Subject: RE: Stanton Andrews: Halsteads Farm
Date: Wednesday 10 April 2024 at 14:25:20 British Summer Time
From: [REDACTED]
To: [REDACTED]
Attachments: image001.png, image002.png, image003.png

Informal assessment

Halsteads Farm, Rimington Lane Rimington, BB7 4EA

Drawing file: planx_downloads / 24_0515_0516_Proposed_Elevations_2.pdf

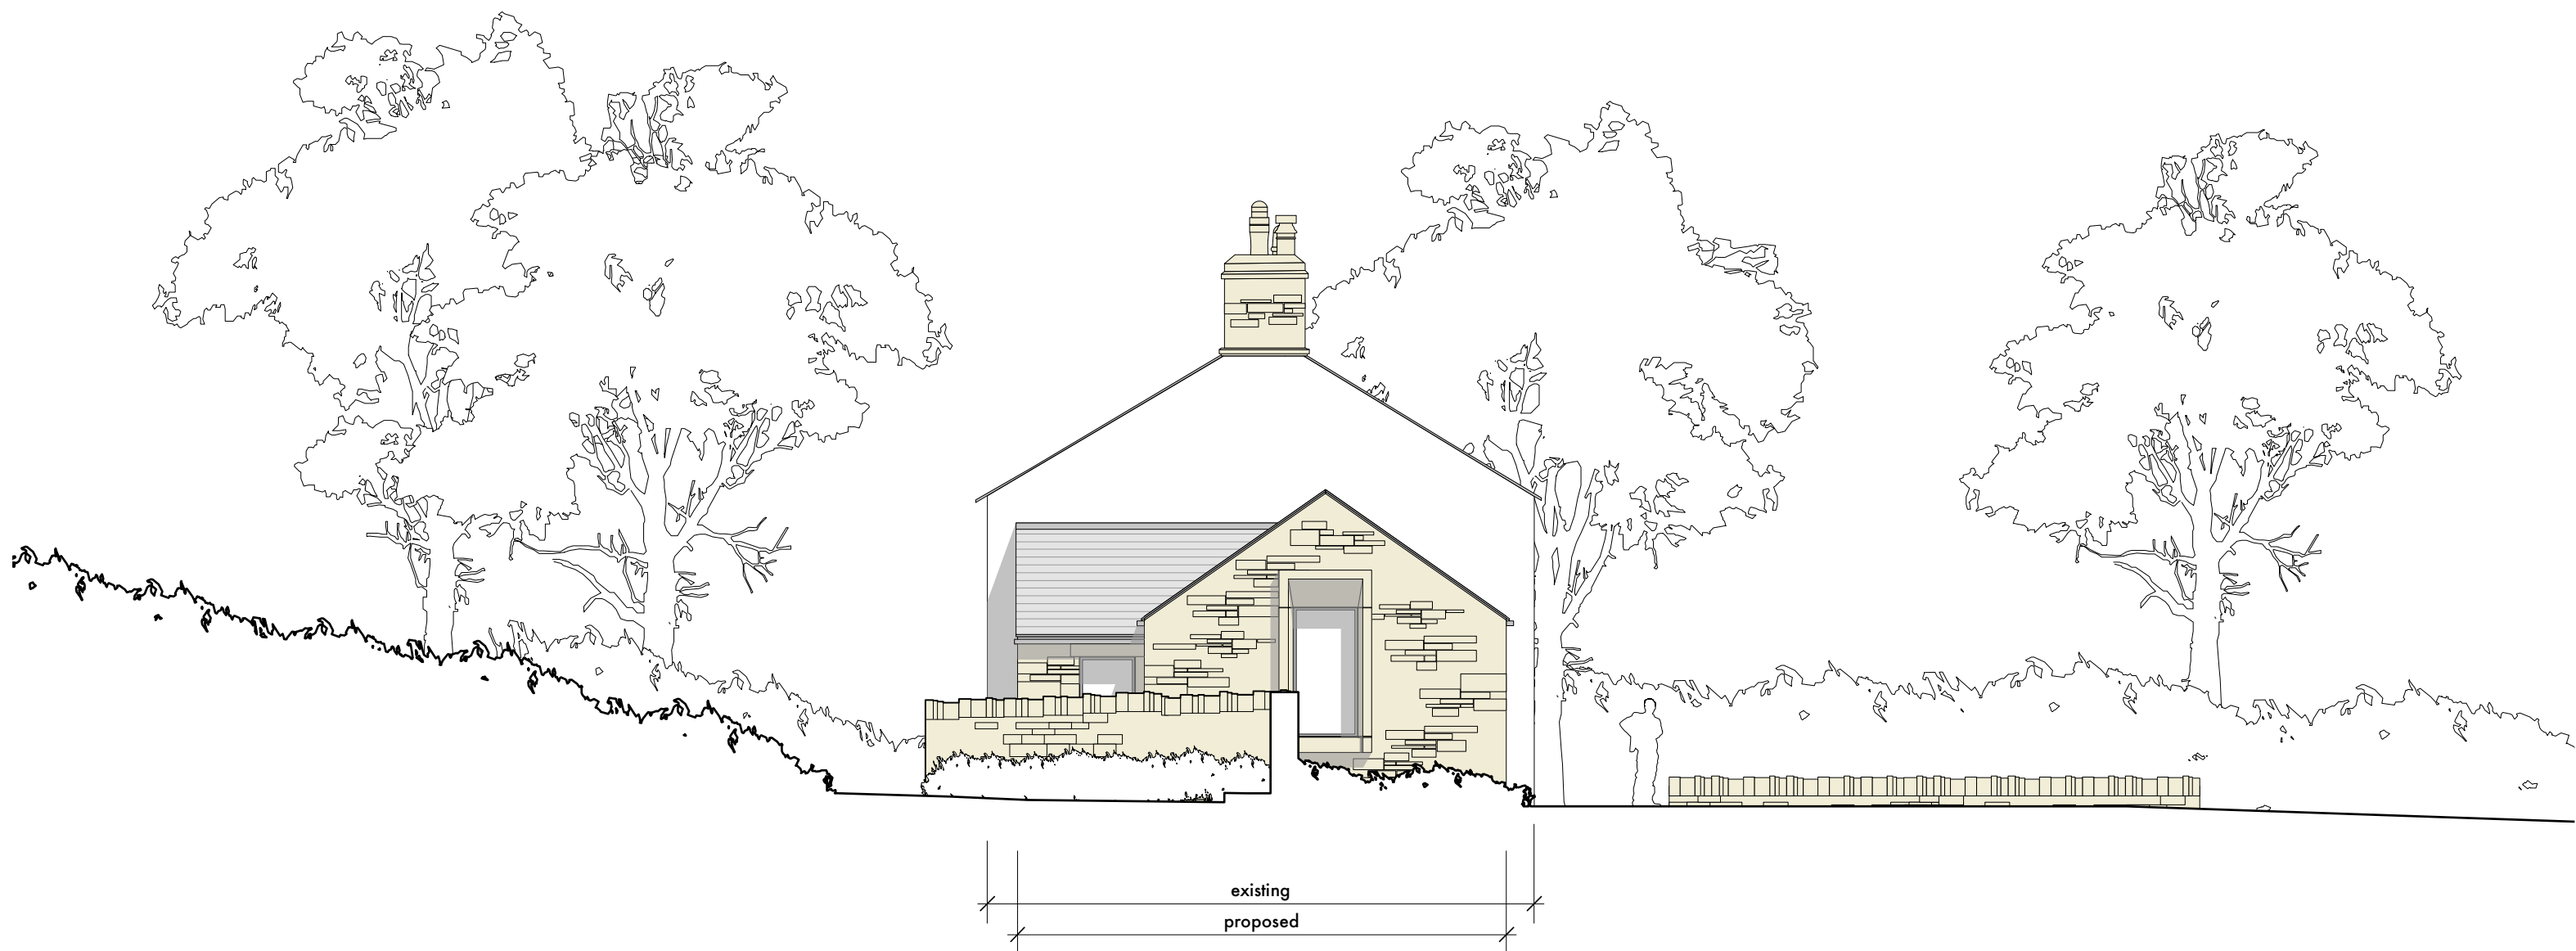
- *Extension width:* I can see that the overall width of the extension & link has been reduced slightly in the revised scheme however the extension as a whole in my opinion still reads as an over dominant addition in terms of its width (issues where identified with respect to the extent of the extension's width in the previous refusal)

- *Extension depth:* It would appear that the depth of the extension has been largely retained from the refused proposal (issues where identified with respect to the extent of the extension's depth in the previous refusal)

- *Extension height:* I can see that a gabled roof design has now been incorporated however the height of the currently proposed extension now exceeds the height of the previously refused flat roof extension which in my opinion exacerbates the bulk and massing of the currently proposed extension

- *Extension alignment:* The South-eastern projection of the extension has been reduced however this part of the extension still projects forward of the farmhouse's South-eastern elevation (issues where identified with respect to the extension's projection forward of the farmhouse in the previous refusal)

- *Roof lights:* Traditional farm buildings are predominantly characterised by their long and unbroken roof slopes – the addition of numerous roof light openings to both roof slopes of the proposed extension would therefore in my opinion read as incongruous with the largely unbroken (save for three existing single roof light openings) roof slopes of the farmhouse and adjoining barn

- *Fenestration:* large glazed openings have been retained for the currently proposed extension (South-eastern elevation / South-western gable end) (issues where identified with respect to large glazed openings in the previous refusal)

Significant reductions should be considered with respect to the following components of any future proposal for an extension to the property as proposed:

- Extension width
- Extension depth
- Extension height

- Roof light quantity

- Extension alignment (to be set behind the South-eastern elevation of the farmhouse)
- Fenestration: avoid the incorporation of large glazed openings
